PRE-APPLICATION ADVICE

Land Adjacent to Old Vicarage Farm

Pre-application for the creation of a new field gate access onto Old Vicarage Lane, Bashall Eaves.

6880 - P02A

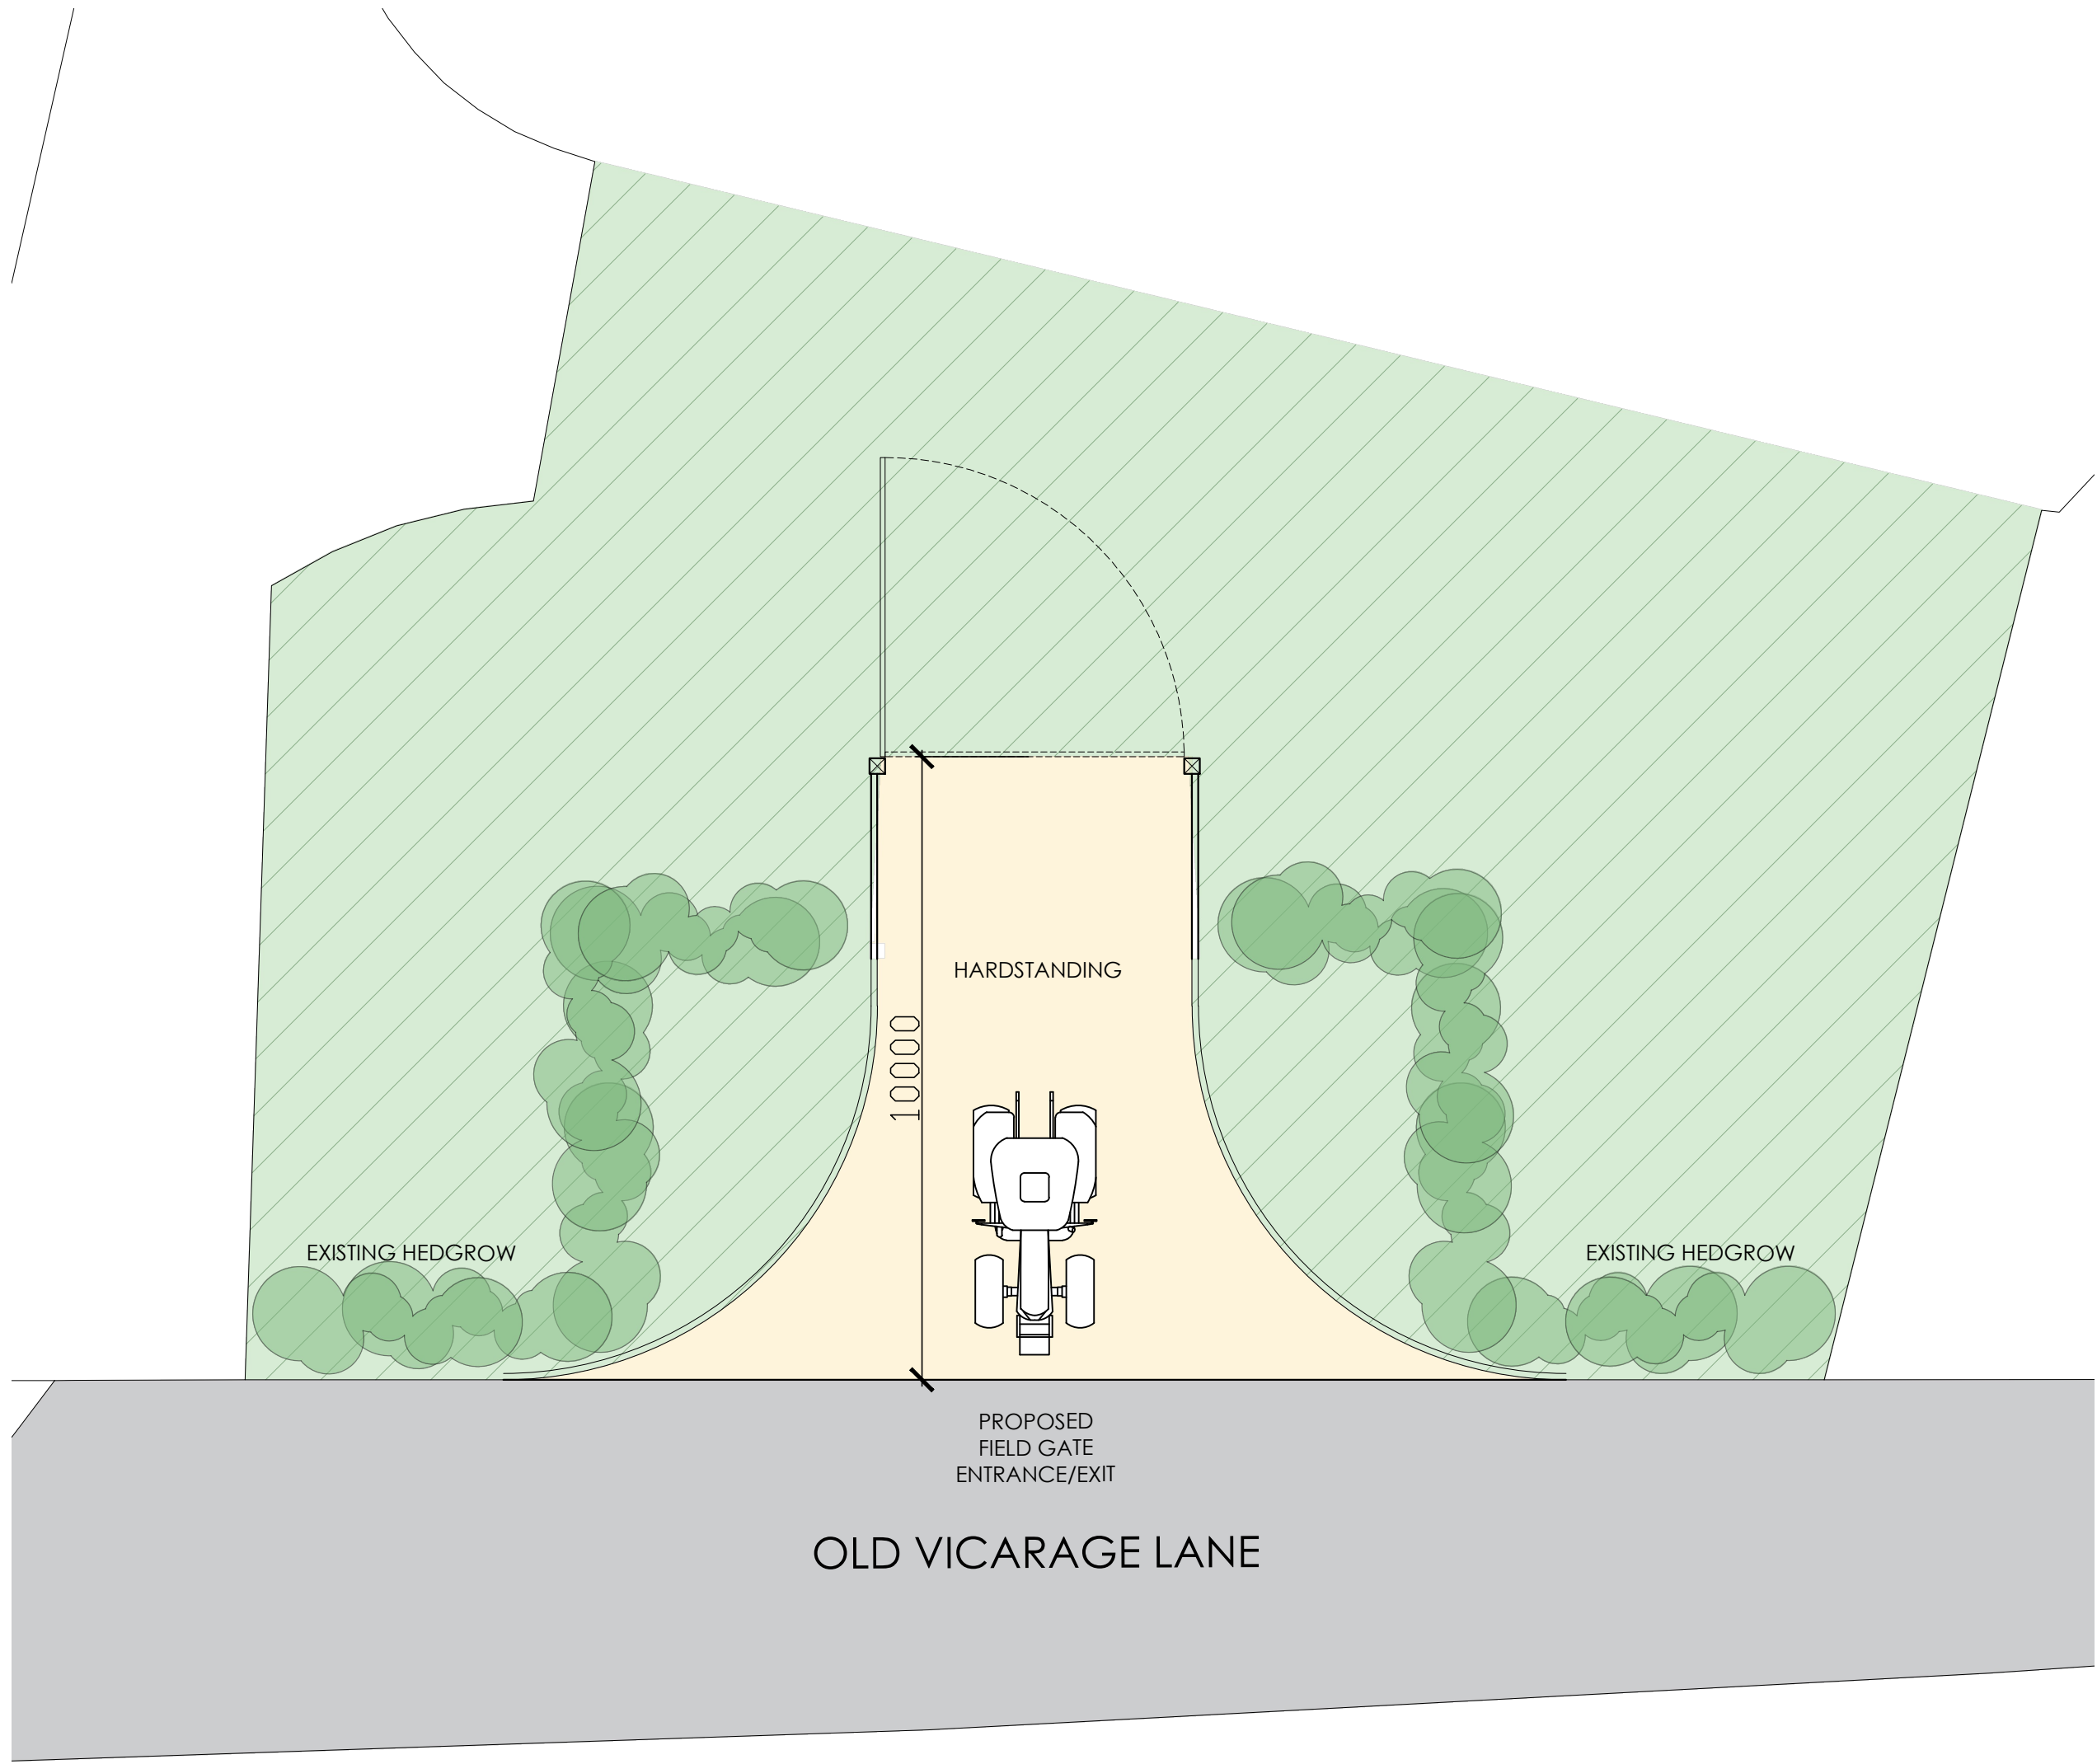
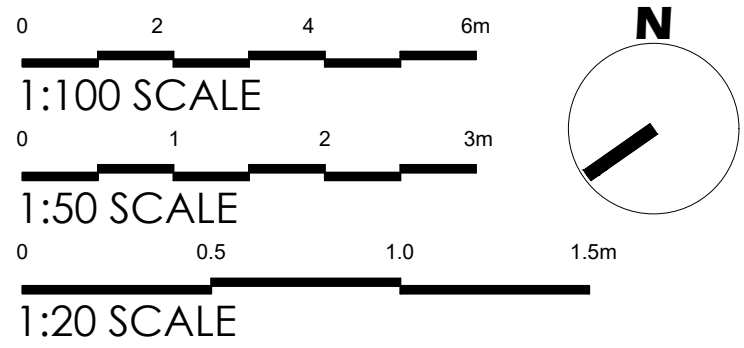
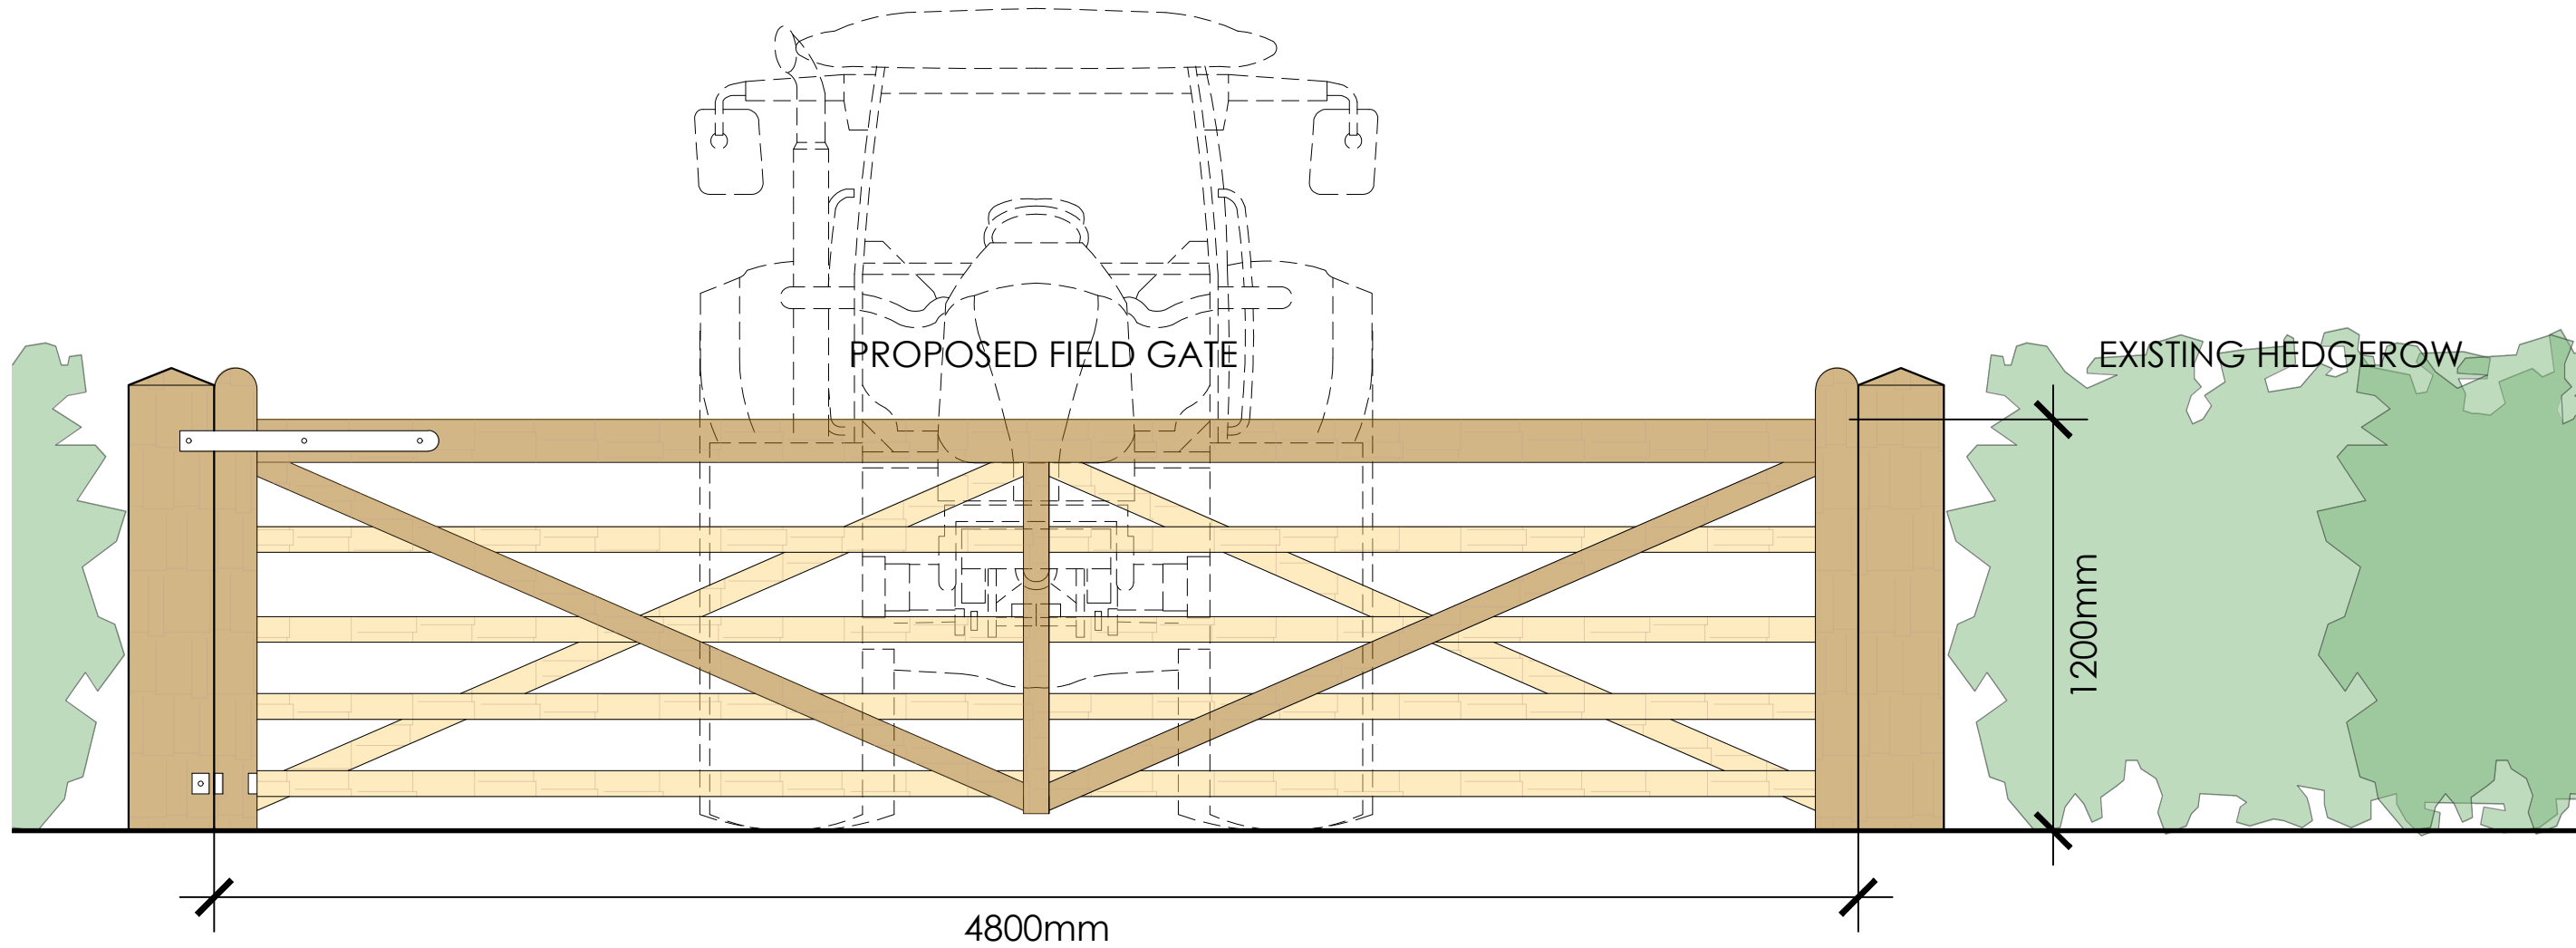
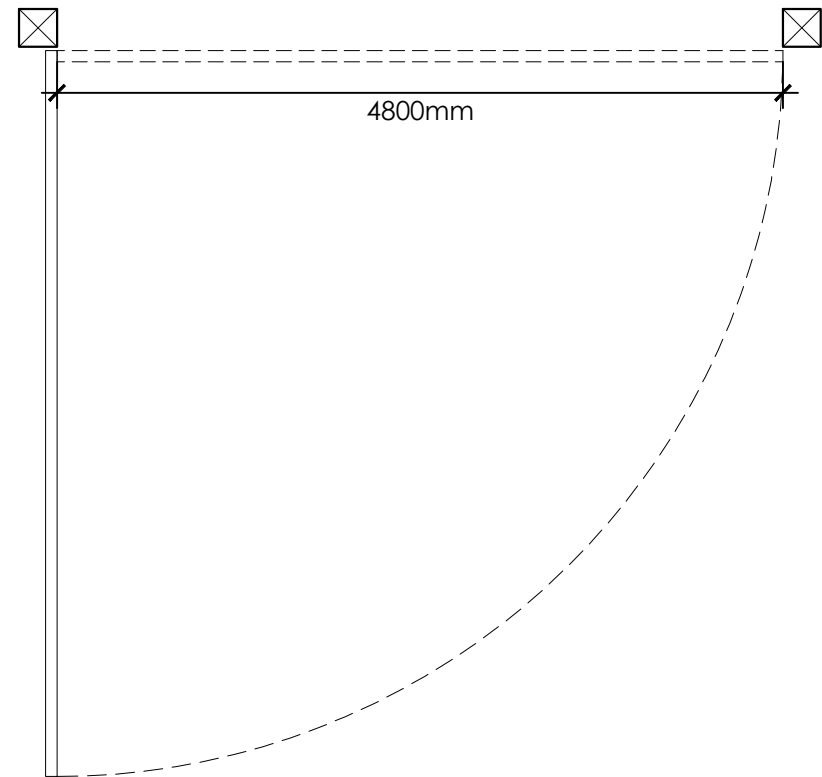
Old Vicarage Lane is an unclassified rural road subject to the national speed limit at the point of the proposed access. The carriageway is predominantly single-track in width. Two options for the access arrangements have been put forward, which are shown on drawing number 6880-P02.

Option 1 proposes a gate positioned immediately adjacent to the carriageway edge. This arrangement does not comply with current LHA standards, as it fails to provide sufficient space for a vehicle to pull clear of the highway before operating the gate. This presents an unacceptable risk of obstruction and conflict with other road users. Additionally, no hardstanding is proposed, which increases the likelihood of debris being deposited on the carriageway, creating a potential skidding hazard. For these reasons, Option 1 is not acceptable to the LHA.

Option 2 proposes the gate setback 7 metres from the carriageway edge, with the first 7 metres surfaced in a hardstanding material to minimise the transfer of mud onto the highway. While this represents an improvement, LHA standards for agricultural accesses require a minimum gate setback of 10 metres, with a corresponding 10 metre hardstanding. The LHA would therefore expect the formal planning submission to reflect the full 10 metre requirement.

Based on the information submitted and the LHA's on-site assessment, the principle of creating a new agricultural access at this location is considered acceptable, subject to amendments at the formal planning stage. Option 2 provides a broadly suitable foundation for an access design; however, the gate setback and hardstanding must be increased to the LHA's required 10 metres.
